April 24, 2017

**Ms. Jean Fraser, Planner**  
City of Portland Planning  
389 Congress Street  
Portland, ME 04101

**Subject: 1039 Riverside Street, Second Tee Business Park Unit 1  
Final Site Plans  
Letter of Response #2**

SHEET TITLE
SITE LAYOUT, UTILITY AND
LANDSCAPE PLAN

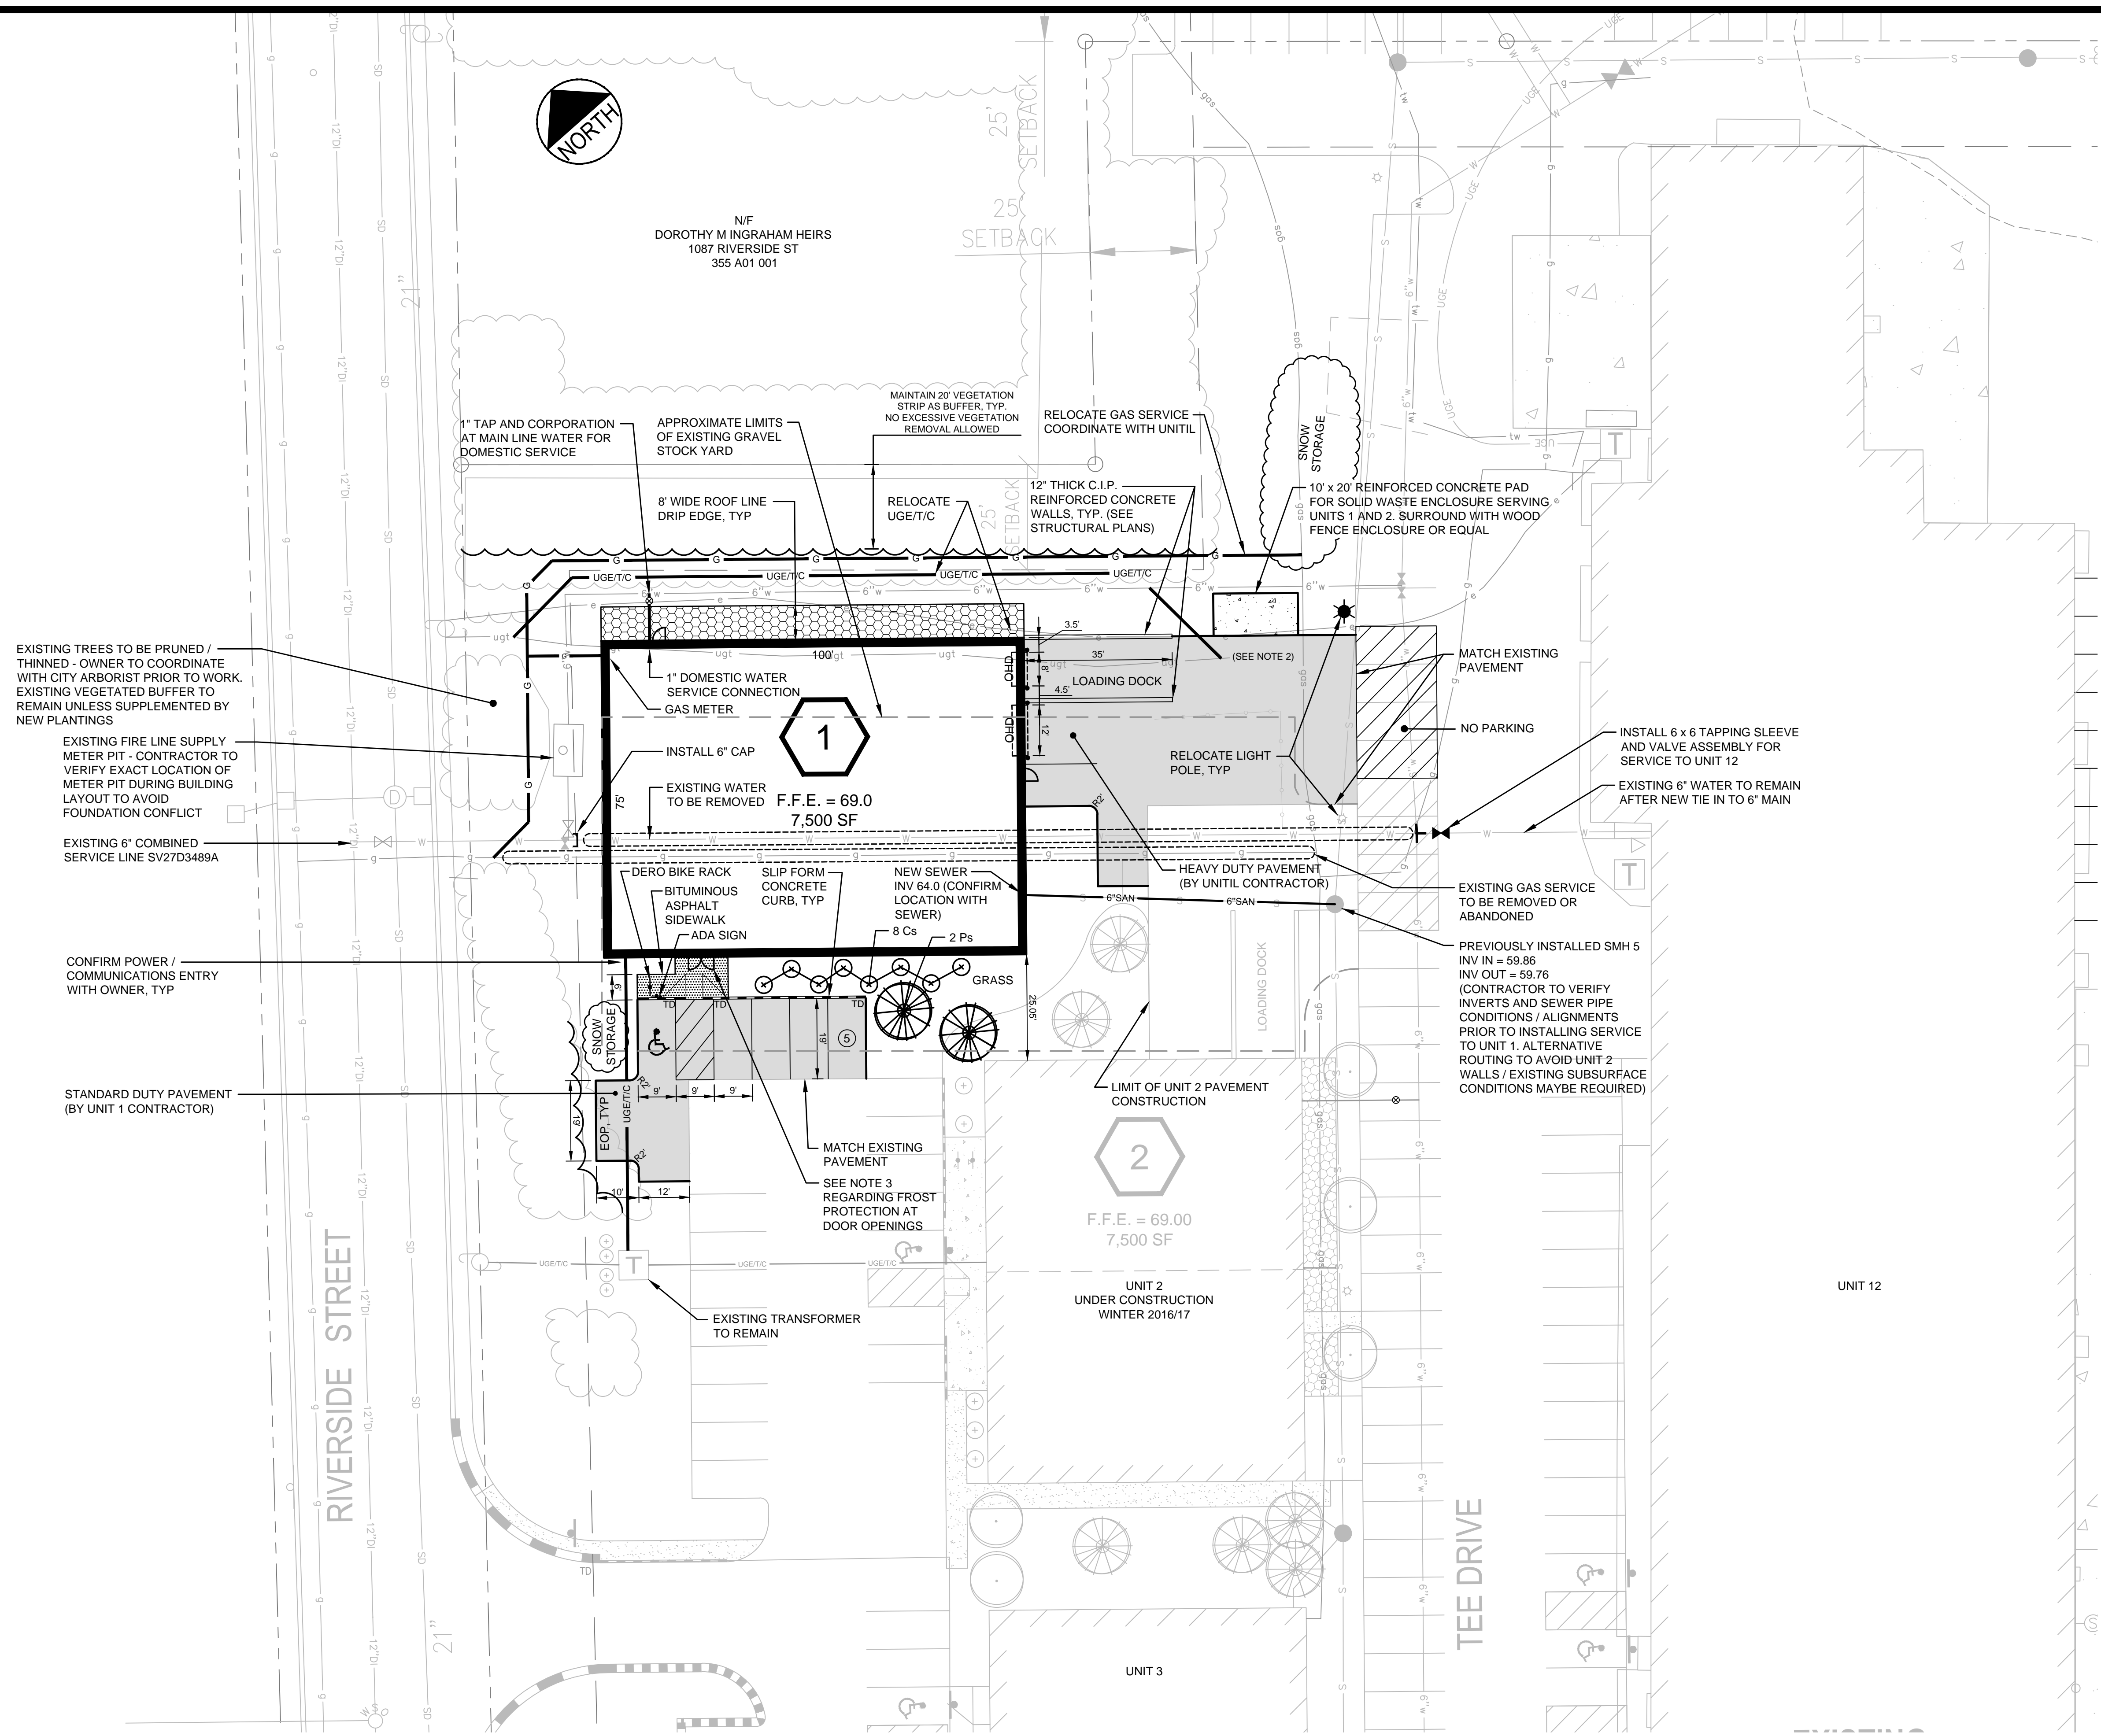
In response to your April 21, 2017 email regarding Jeff Tarling's comments on the Unit 1 proposal we have updated the Site plan to include some notes regarding the buffers along Riverside Street and the neighboring property. We have also added a few more plantings per Mr. Tarling's comments. Accompanying this response letter is a pdf of the revised plan.
